AQUIND INTERCONNECTOR

Statement of Common Ground Between
AQUIND Limited and Historic England

Document Ref: 7.5.13

DATE: 23 DECEMBER 2020

EN020022-2.11-PARA-Sheet1	Application document reference 2.11 Optical Regeneration Station(s) Parameter Plan Sheet 1 of 1
---------------------------	--

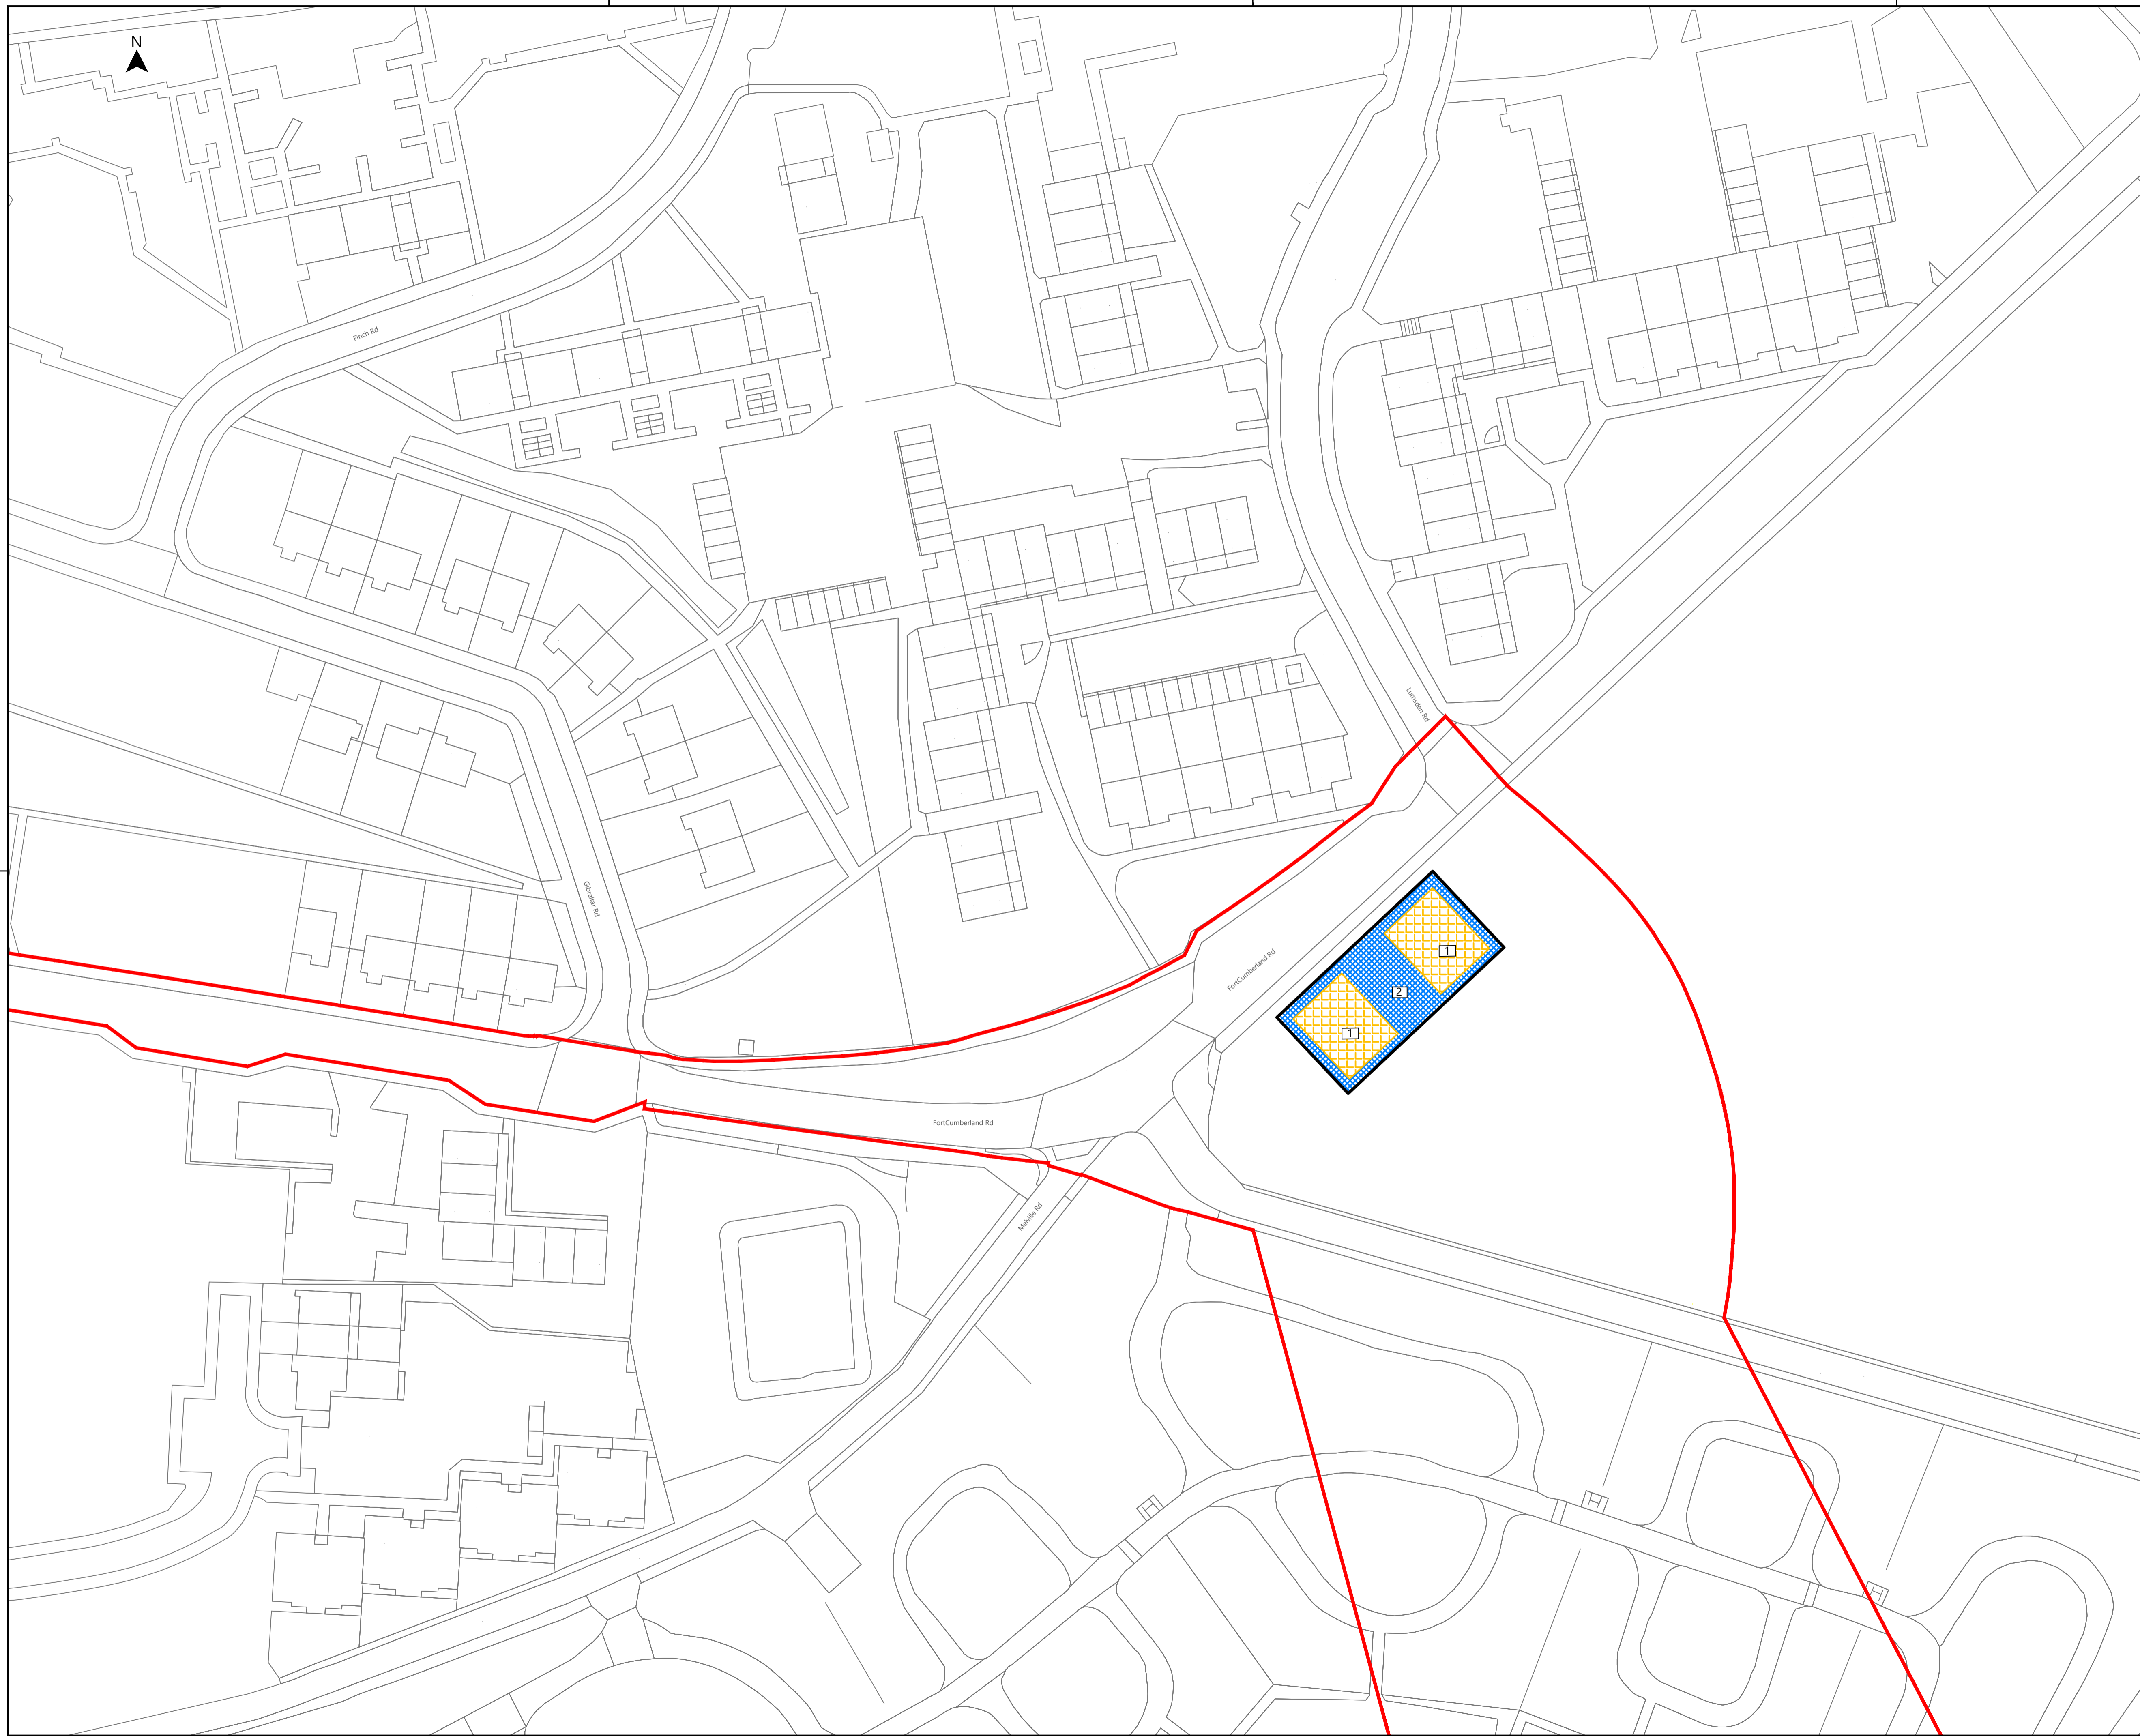
3.1.5	Landfall - Fort Cumberland, Setting (Level of Harm) (2)	<p>AQUIND position:</p> <p>The Applicant considers the impact to the significance of Fort Cumberland is negligible in respect of views from the western ravelin, based on the distance from the asset and the presence of a modern residential housing estate, located 15m to the north-west of the proposed ORS compound. The site of the proposed ORS compound is currently in use as a car park. The Applicant considers that the landward view from the western ravelin has been substantially altered since the construction of a 1960s housing estate (located 15m north of the Proposed Development) and 20th century motor shed adjacent to the north. The surrounding housing estate, trees and parked cars have significantly impacted the open coastal plain in views looking out from the western ravelin towards the Landfall and Fort Cumberland Road, including what were lines of fire from the fort. The location of the proposed ORS compound would introduce a new built form in long views out from the western ravelin towards Fort Cumberland Road. However, the proposed ORS would be lower in height than the current housing estate, and when seen against the background of the surrounding residential development would not be visually intrusive. Taken overall, the ORS would not have a significant impact on how the asset is appreciated and</p>	Not agreed

Ref.	Description of matter	Details of Agreement	RAG
		<p>particular, and its relationship with the monument. Historic England request to see the line of sight maintained to maximum extent, through the redesign or repositioning of the ORS.</p> <p>Outcome of further discussions</p> <p>This matter has been subject to further discussion between the parties following submission of the further visualisations contained with the ES Addendum at Deadline 1 (Document Ref 7.8.1). A teleconference meeting was held on 26 October 2020, where the additional submissions were discussed.</p> <p>Based on the additional information provided Historic England do not agree that the level of harm remains negligible and consider the impact to Fort Cumberland as ‘less than substantial harm’ (Overarching National Policy Statement EN-1 terminology). Historic England note that the visualisations do not provide an accurate representation of the view from the western ravelin itself, which is at an elevated position. As such, there is a possibility that the road convergence would be visible over the buildings from the ravelin, but this cannot be confirmed without a viewpoint from the ravelin itself. Historic England consider that the visualisations indicate (combined with viewpoint photos from the ravelin) that there would still be an impact on the view of Fort Cumberland Road even from the higher point.</p> <p>It has been agreed between the parties that the proposed Optical Regeneration Station (ORS) would not result in substantial harm to the Fort Cumberland Scheduled Monument and Grade II* listed building (see 3.1.5). Historic England maintain that the level of harm is less than substantial whilst the applicant considers the overall effect to Fort Cumberland scheduled monument is negligible. Irrespective of this differing professional opinion, in EIA terms the proposed change would not constitute a ‘significant’ environmental effect warranting substantial design amendments to the proposed scheme.</p> <p>The applicant will continue to consult with Historic England regarding reserved matters relating to building design such as materials and palette but do not consider further assessment work necessary. As outlined in Section 5.8 in (EN-1) it will be for the examining authority to decide whether any perceived harm has clear justification, in order to weigh that perceived harm against the public benefits of the development. The applicant makes note of the Needs and Benefits</p>

Ref.	Description of matter	Details of Agreement	RAG
		<p>understood. The overall environmental effect is therefore considered negligible.</p> <p>Following submission of the DCO application, It was agreed that an adjacent viewpoint would be used to provide further assurance that the significance of the fort would be unaffected, as access at the time was not possible due to Covid-19 restrictions. Landscape Viewpoint 22 was used to create photomontages showing the scale and massing of the two proposed ORS placement options (illustrated in Figure 15.56 of the Environmental Statement) (APP-289).</p> <p>An additional visualisation as agreed by Historic England was presented at Deadline 1 (Environmental Statement Addendum – Appendix 10 - Figure 5 Historic England Visualisations (REP1-141)). Although the Applicant acknowledges that the ORS would be visible in views from the western ravelin from Fort Cumberland, the overall effect as assessed in ES Chapter 21 (Heritage and Archaeology) (APP-136) remains negligible and as such the visualisation supports the conclusion of the settings assessment in ES Chapter 21 (Heritage and Archaeology) (APP-136).</p> <p>Historic England's position:</p> <p>With regard to Fort Cumberland, Historic England consider there to be a level of harm, equating to less than substantial, which is higher than that suggested by the Environmental Statement. HE consider that the siting and scale of the ORS could cause some harm to the view from the western ravelin at Fort Cumberland towards Fort Cumberland Road. Historic England do not agree with how the level of harm has been identified in consideration of the particular relationship that exists between Fort Cumberland, its field of fire and, in particular, the visual association between the ravelin and the approach road from Portsmouth.</p> <p>Historic England note that sightlines, fields of fire, and connectivity with land and sea based approaches, are integral to the significance of the fort. Relationships with other fortifications alongside primary approach routes and attacking points confer additional context and coherence which also contributes strongly to Fort Cumberland's significance. Historic England acknowledge that the setting of the fort was altered significantly during the mid-late 20th century, through residential development in the wider surrounding area. Despite this it is still possible to view, appreciate and understand the landward approach to the site, via Fort Cumberland Road in</p>
